26 October 2022

**Exhibition of State Significant Infrastructure Application
INLAND RAIL – ILLABO to STOCKINBINGAL
Application number SSI-9406**

Junee Shire Council (JSC) welcomes the opportunity to make a submission in relation to Inland Rail's (IR) Illabo to Stockinbingal (I2S) Environmental Impact Statement (EIS).

FIGURE 8-3: INDICATIVE BURLEY GRIFFIN WAY REALIGNMENT AND RELATED RAIL WORKS

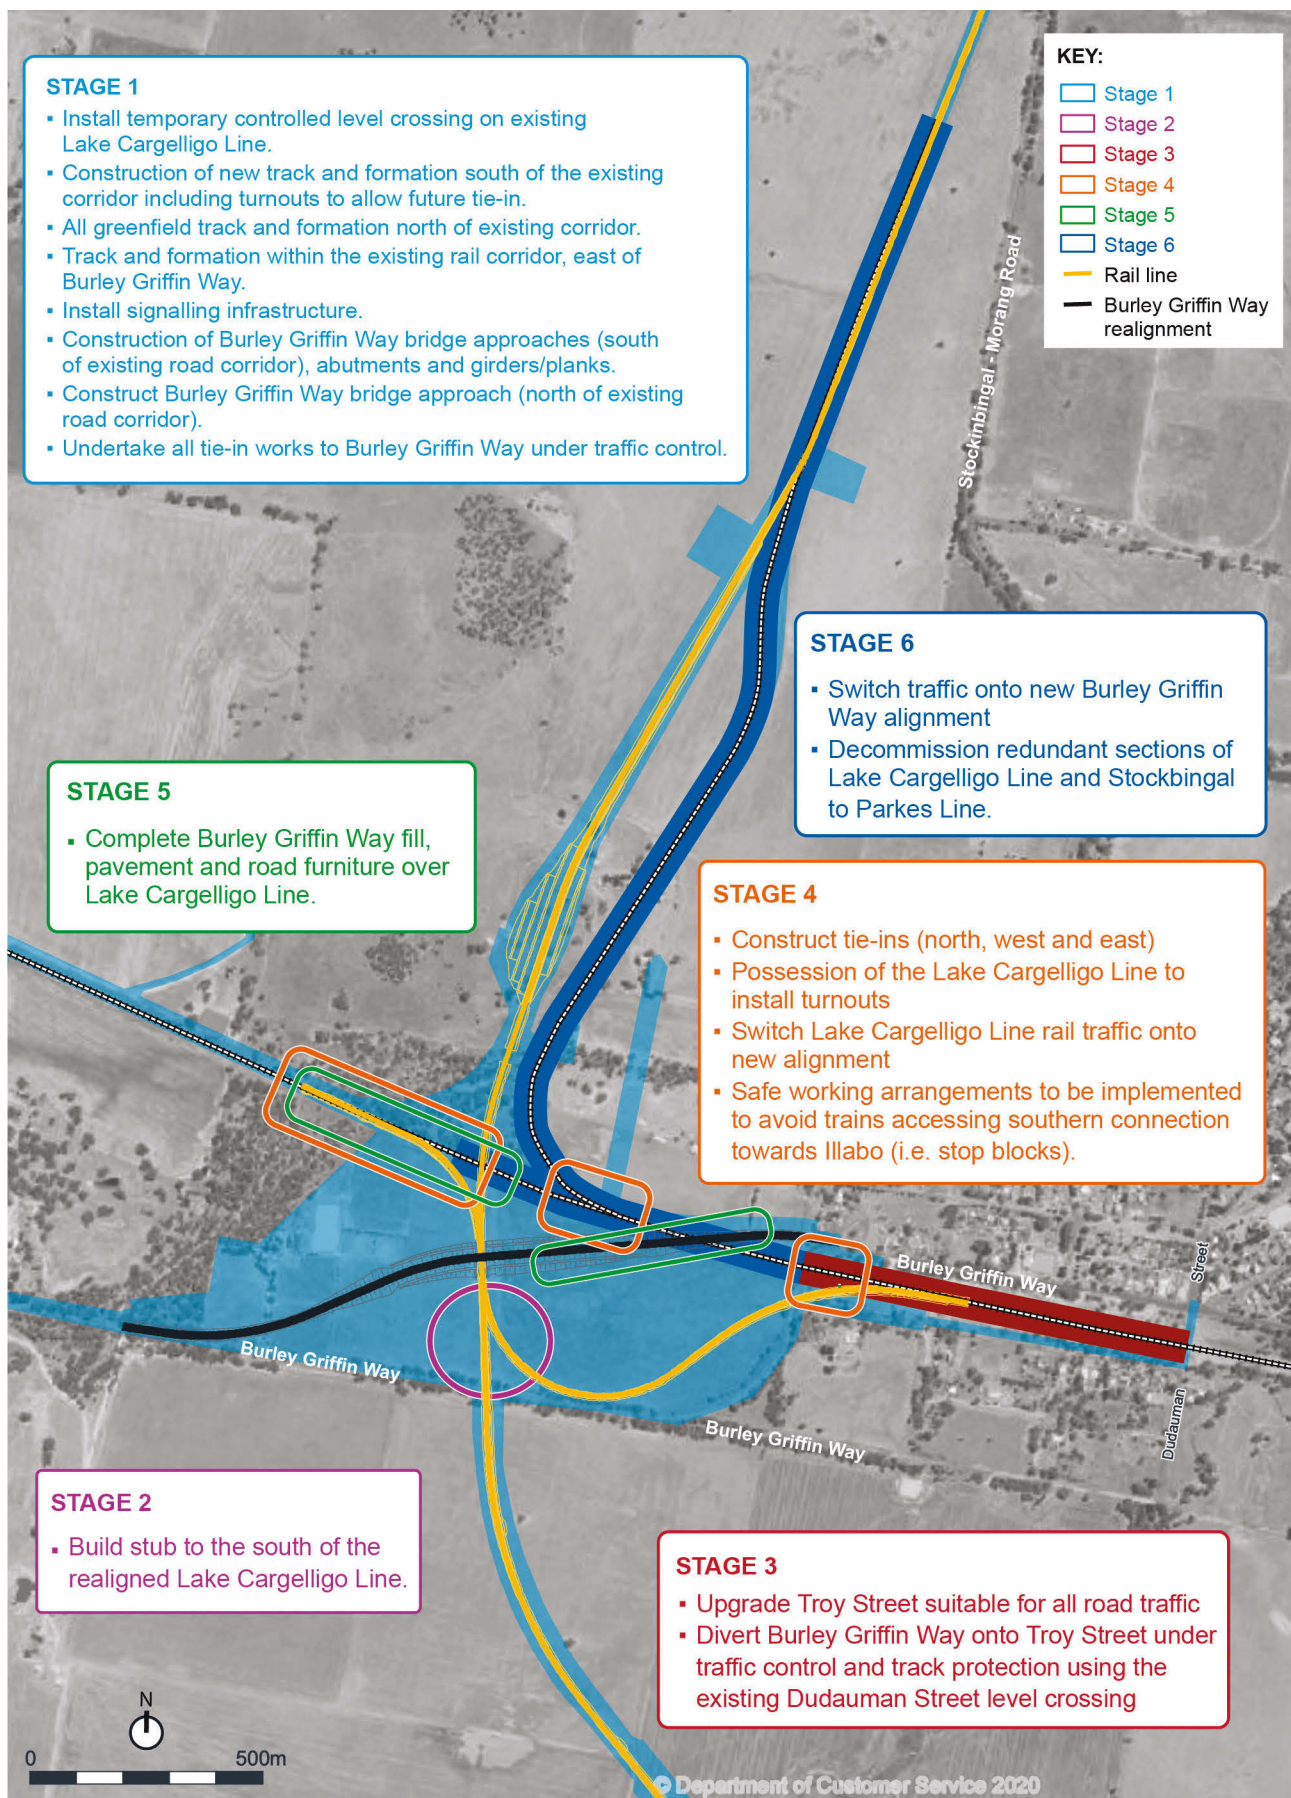
Ch8.2.8.2	Road Modification Ironbong Road	To be addressed	<p>Figure 8-3 has a staging plan for Burley Griffin way realignment, outlining the proposed staging and works for this realignment. Although significantly less complicated, it would be beneficial to include a similar schematic in the EIS showing the staging of the Ironbong Road realignment, being the only other major road realignment work for this section of the Inland Rail.</p> <p>Recommendation: The EIS be updated to include a staging schematic for the proposed realignment of Ironbong Road.</p>
Ch8.2.13	Finishing works and reinstatement	To be addressed	<p>The EIS, in this section and overall, does not adequately address the interface of the proposed works with existing Council infrastructure or utilities in the proposed works area.</p> <p>Recommendation: The EIS should be amended to include approval for the designs for the road and drainage interfaces by Council before being finalised. This section should also detail an agreed quality assurance process for handover of assets back to Council.</p>
